MECKLENBURG COUNTY
Park and Recreation Department

MEMORANDUM

DATE: April 28, 2022

RE: Rezoning Petition #2021-258
PID# 04739101

RZ.01

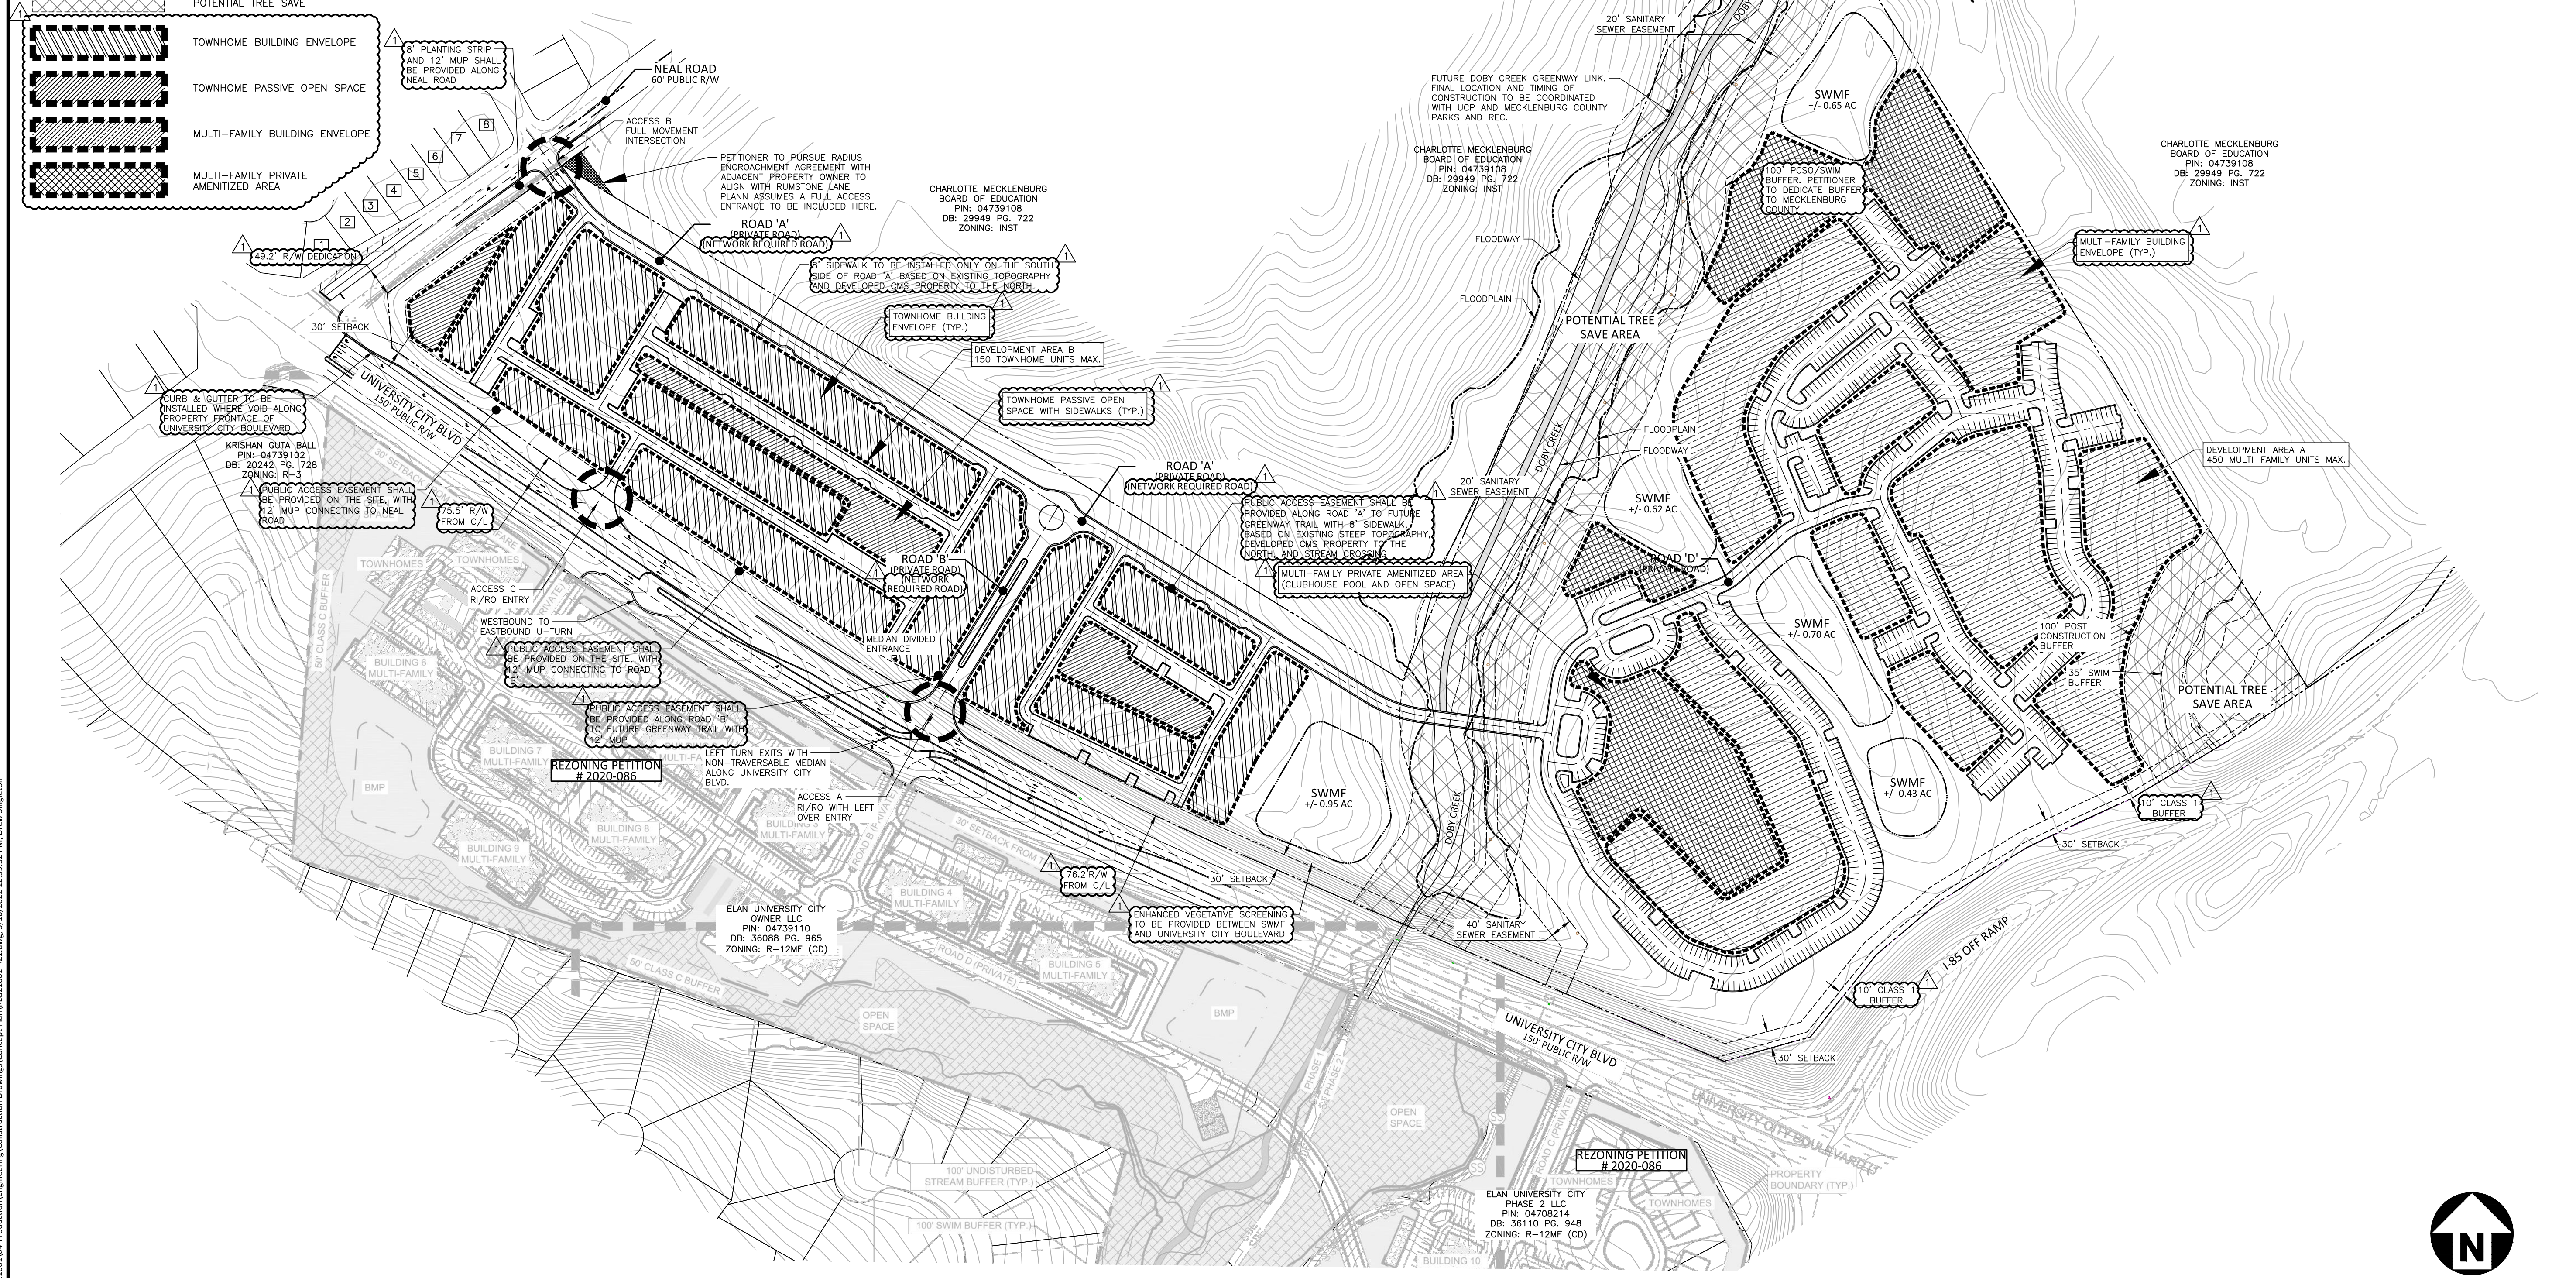
Plans show a proposed greenway dedication. The 100' PCSO Buffer should be "dedicated and conveyed to Mecklenburg County" for greenway trail, not to "Mecklenburg County Parks and Recreation". Please also confirm that the dedication area includes the SWIM buffer on both sides of the creek and 100' wide permanent greenway easements between the dedication area and both Private Road A and Private Road D for future access trail connections that provide an at-grade crossing of University City Blvd at Private Road B. Please refer to comments in Plan Room.
